Submission No.			279	
Organisation Name or Name of Submitter			Shandon Residents Association (48 Shandon Park, Phibsboro)	
Item No.	Section Ref.	Page No.	Observation Statement	TII Response
Letter Re: ABP-314724-22 Railway (MetroLink - Estuary to Charlemont via Dublin Airport) Order [2022] - case number 314724				
1	Note on submission fees and community participation	3	Shandon Residents Association (SRA) objects to the requirement to pay ABP €50 to submit an observation on Metrolink. It’s unfair to penalise those who are financially disadvantaged. The right to comment should not be limited to better-off individuals and groups. It’s important that an open oral hearing forms part of this planning process to provide the opportunity to engage fully with such a seismic change to the area.	<p>Thank you for your submission and for sharing your observations with regards to the MetroLink project to which we have responded below.</p> <p>An overview of the Oral Hearing process is provided in the EIAR Chapter 8.9.2. An Board Pleanála have confirmed an Oral Hearing will be held. The purpose of the oral hearing will be to allow issues relevant to an application for approval be examined. The oral

Client	TII NTA	Project	METROLINK	Drawing Title	METROLINK- STRUCTURES GLASNEVIN STATION PROPOSED STREET LEVEL DESIGN	Drawing Status	S0
Consultant	JACOBS IDOM	Drawing N°	ML1-JAI-SRD-ROUT_XX-DR-Y-02057	Plan Drawing N°	ML-ST 304 N-01	Sheet 1 of 8	
Scales Original Size A1		1:250

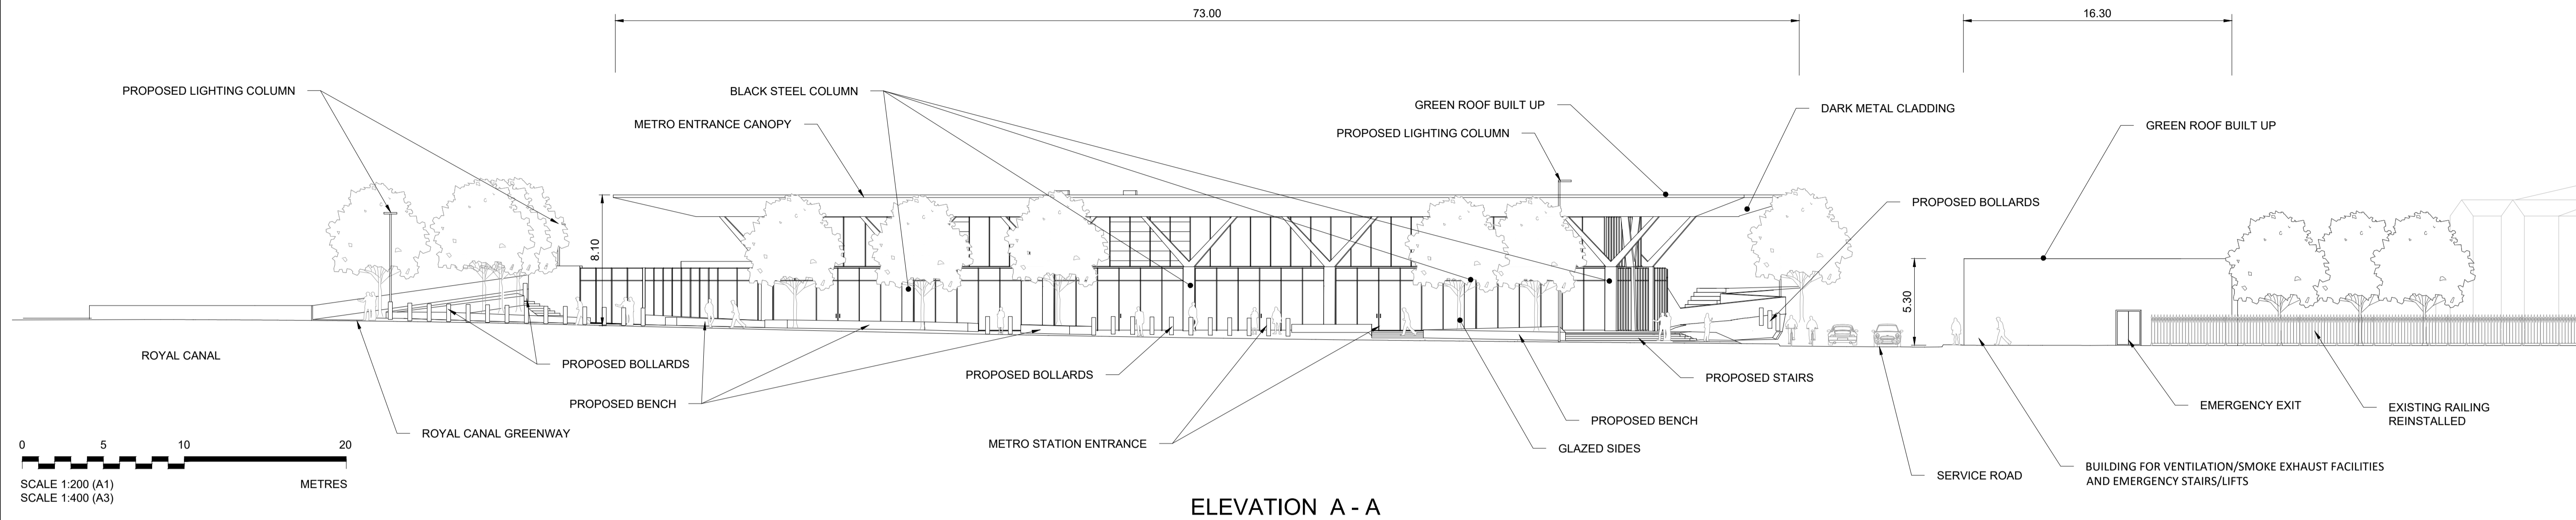
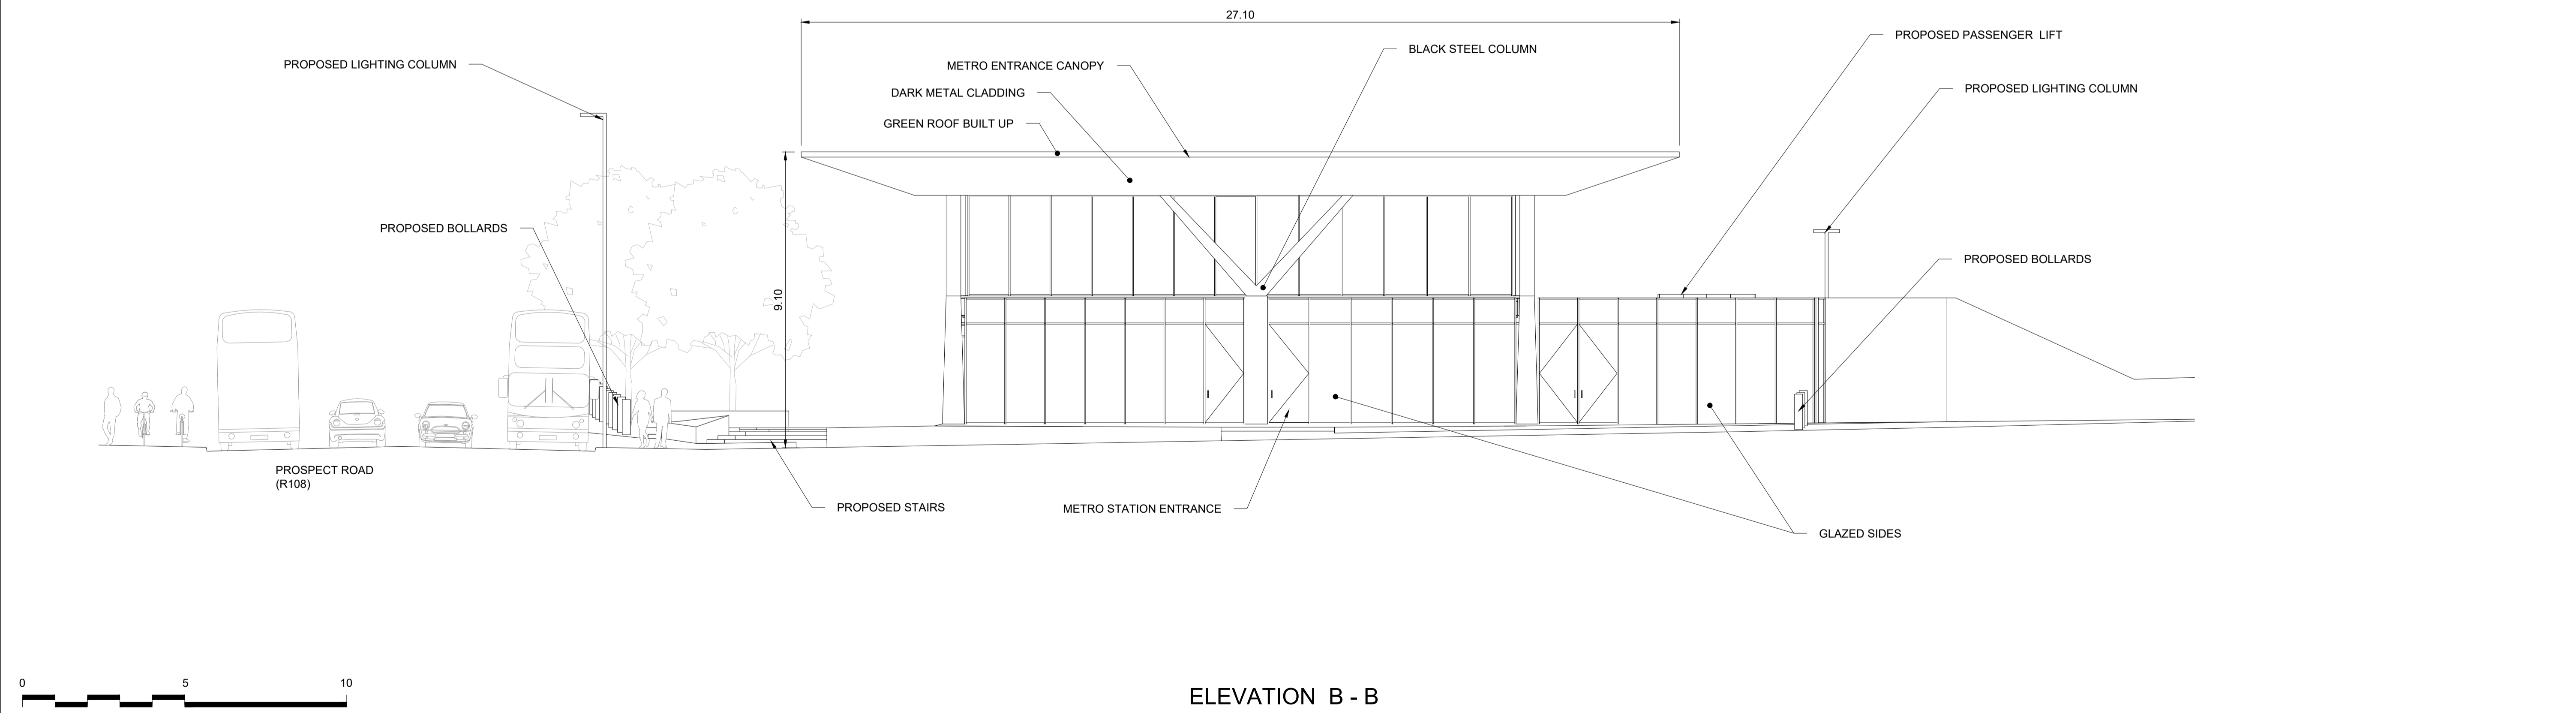
9	Section 3 — Planning conditions	8 and 9	Open Public Architectural Competition to design Glasnevin Station. This station is arguably the most important as it exists as an Irish Rail/Metrolink interchange. The designs shown in the plans do not appear to reference any of the rich heritage and history of this area of the city. Glasnevin Station will sit alongside the cornerstone of the Royal Canal, where its building works began in 1790 and the Brian Boru pub is an important historic site where Brian Boru gathered his army in defence of Ireland prior to the Battle of Clontarf.	<p>TII believe the commissioning of internationally renowned architect Nicholas Grimshaw and Partners, has delivered a contemporary station design which is appropriate for a state of the art metro system such as MetroLink. Appropriately, significant emphasis is placed on the public spaces. Where feasible, the station concourse is a soaring space illuminated from above with natural light. Dublin's rich architectural heritage has been respected, but not copied in a pastiche imitation. In accordance with best conservation principles, as set out in the ICOMOS Venice Charter of 1964, the stations are architecturally distinguishable so as not to falsify the existing historic context. Reference and due respect to that context is made through the choice of high quality and appropriate materials and the scale of the interventions. The aesthetic values of all eras, including our own, have cultural validity, and therefore the brick is used in a contemporary way reflecting contemporary aesthetic idioms derived from 21st century technology. TII believe the current station and surface level designs greatly enhance the public realm at all locations along the MetroLink route. There is a unifying commonality in the design of all stations, providing a consistent and coherent architectural language, which assists with orientation and wayfinding, and contributes a new architectural lexicon to the cultural iconography of the city.</p>
